Consultee Comments for Planning Application 17835/24

Application Number: 17835/24

Address: 14 Allenby Grove Westhoughton Bolton BL5 2AQ

Proposal: ERECTION OF SINGLE STOREY EXTENSION TO SIDE AND REAR TOGETHER WITH PORCH TO FRONT

PROPOSED SITE LAYOUT

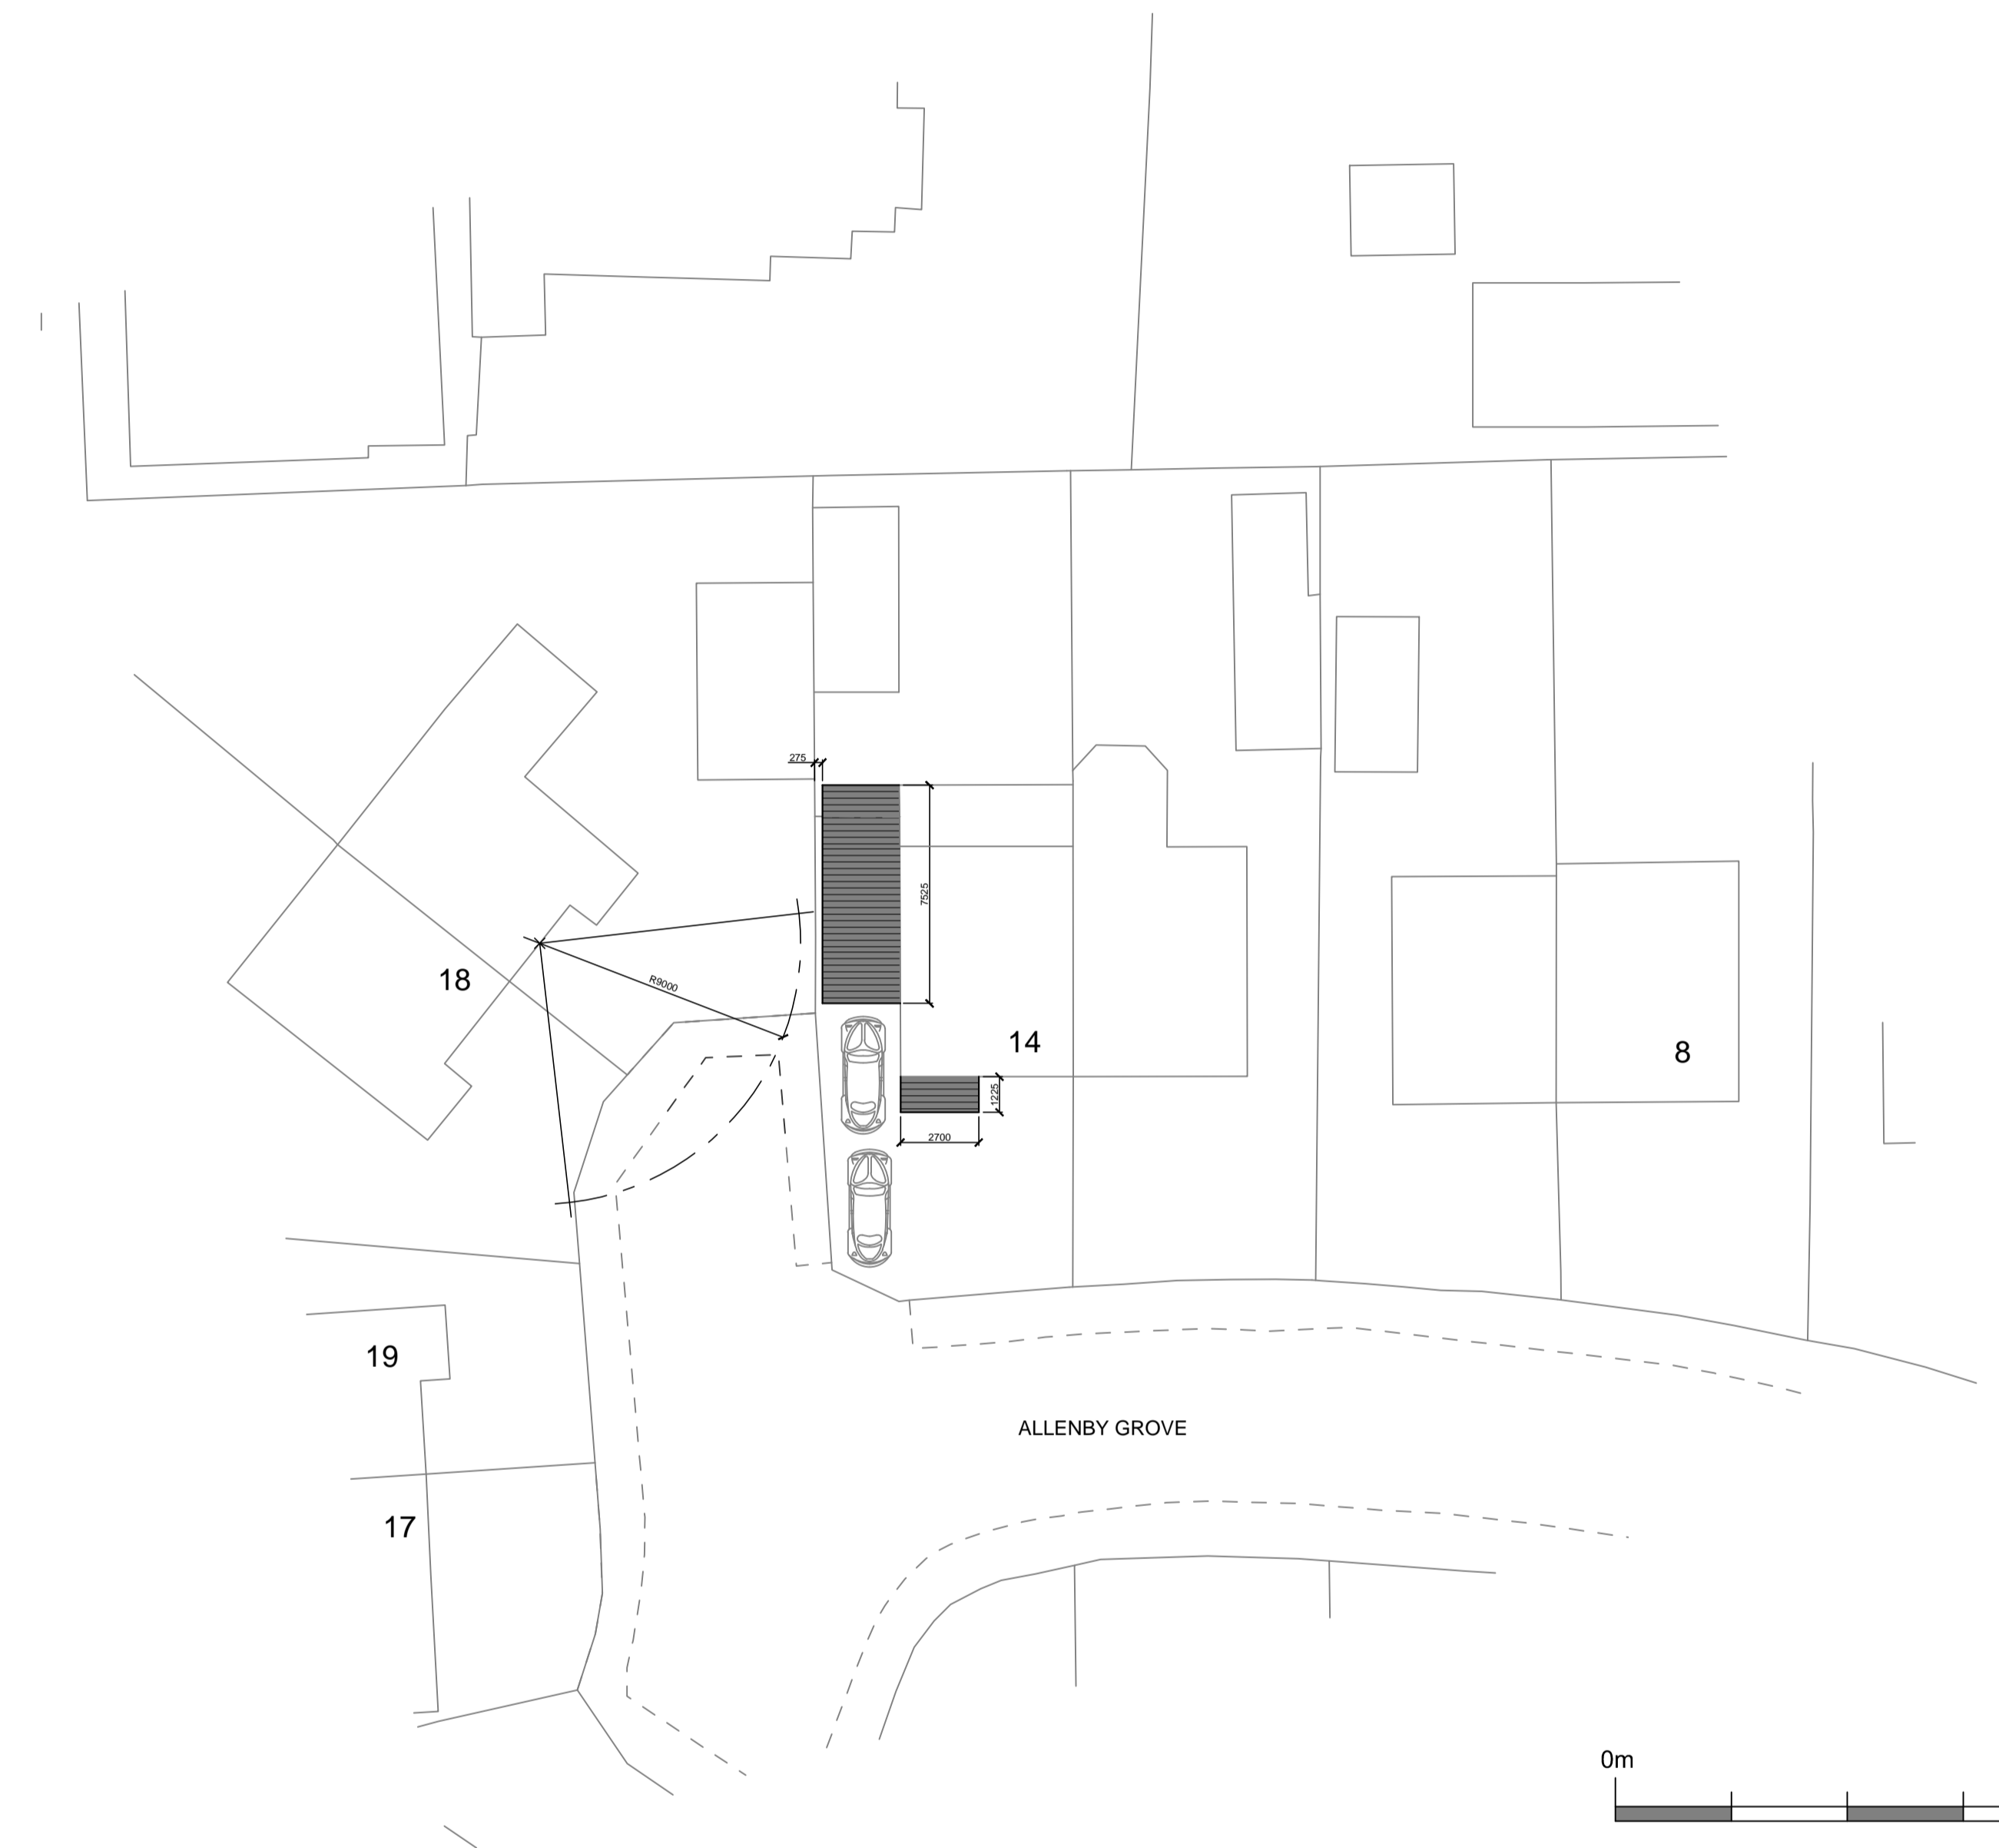
No reasonable objections on highway grounds to what is being proposed under this application.

HS05-2 spaces (2.4m x 4.8m each space).
